MEMORANDUM

TO: Jeff Watson, Community Development Services

SUBJECT: Wenger Short Plat SP-07-07

KITTITAS COUNTY SHORT PLAT NO. 07-07
PORTION OF THE NE 1/4, SEC.29 T.20N., R.14E., W.M.
KITTITAS COUNTY, WASHINGTON

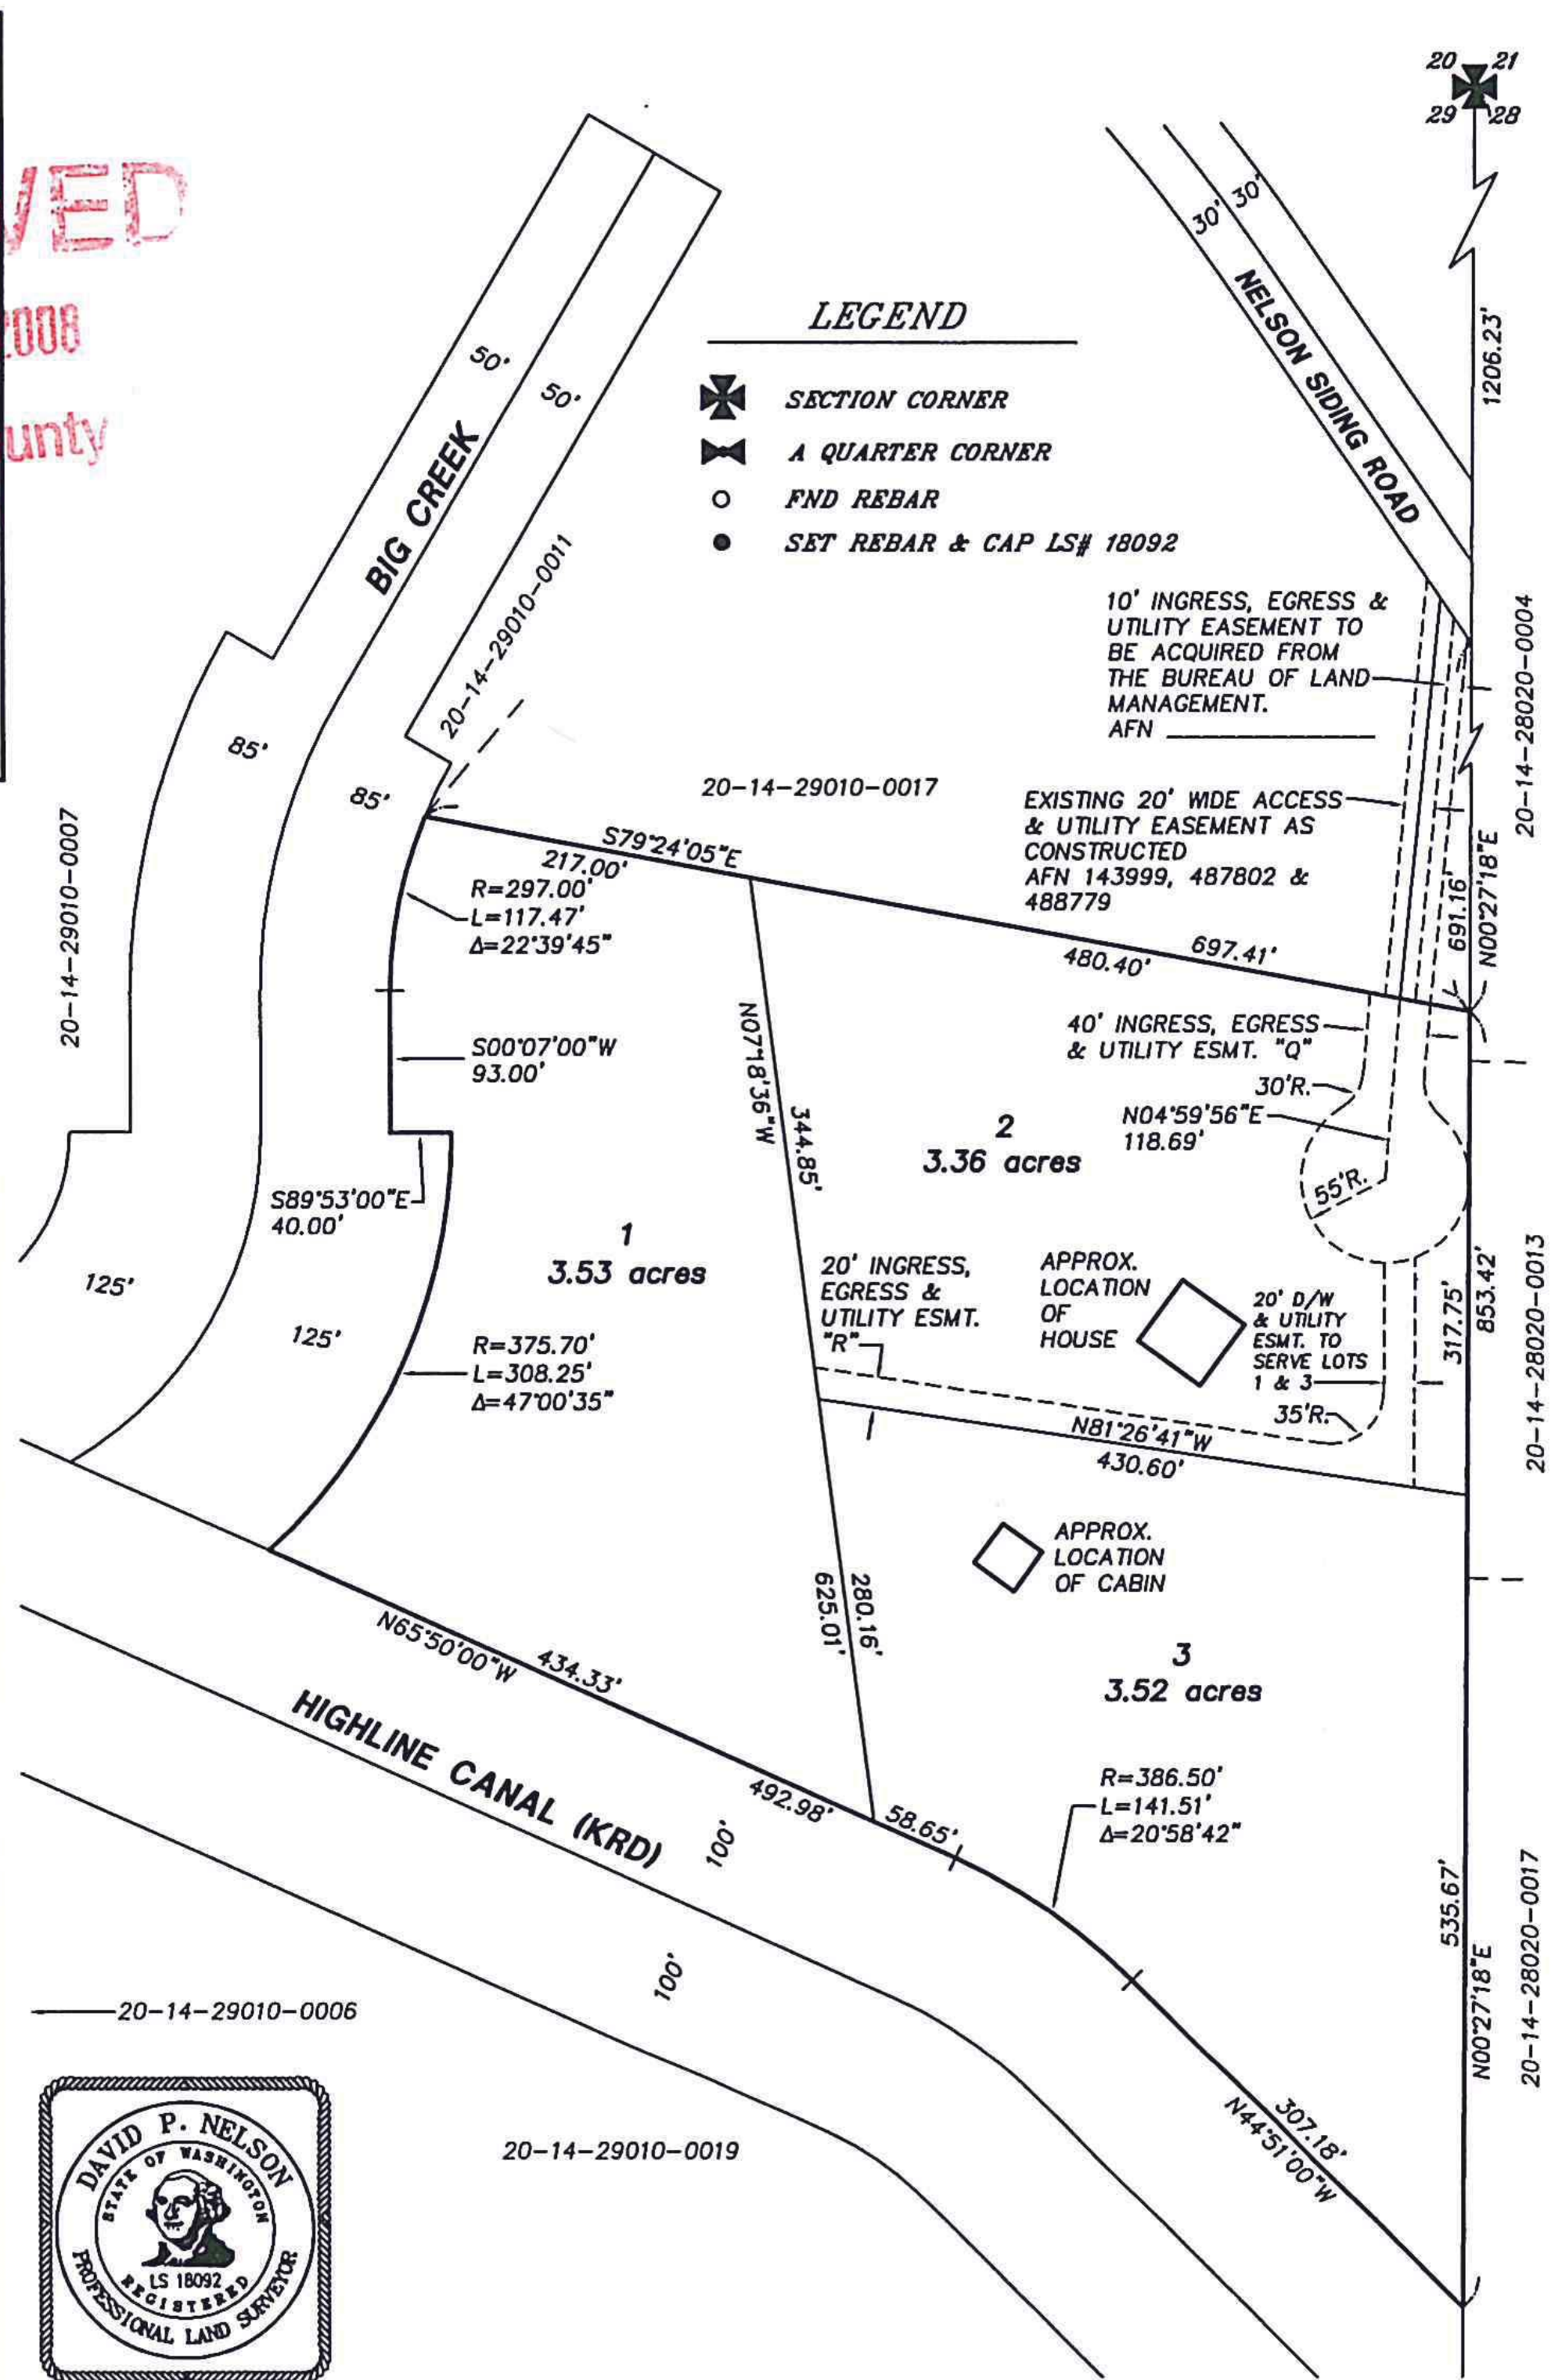
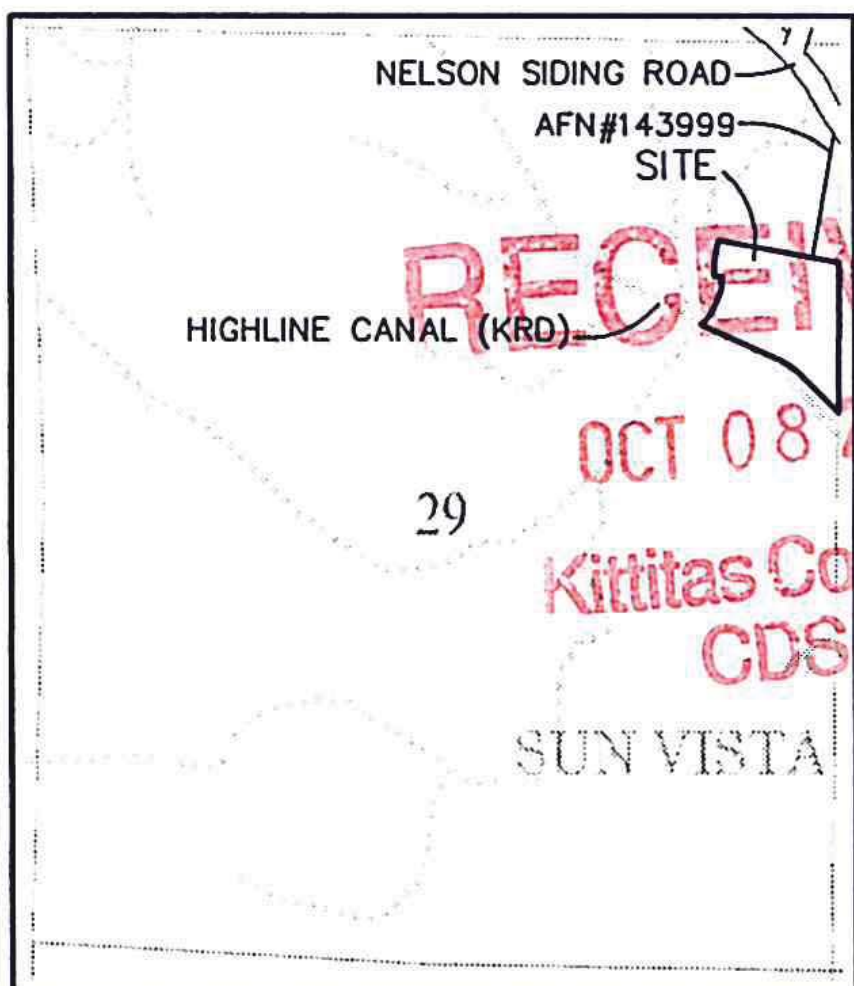
4. Final Plat: The following items must be shown on the final plat:
 - a. 100-year floodplain
 - b. Shoreline jurisdiction
 - c. Big Creek
 - d. KRD Lateral boundaries

- e. Easement and driveway serving parcel 616536
5. Floodplain: A building site must be designated outside of the 100-year floodplain. If any construction of residential or non-residential buildings takes place within the 100-year floodplain, Base Flood Elevations must be determined for the entire subdivision.
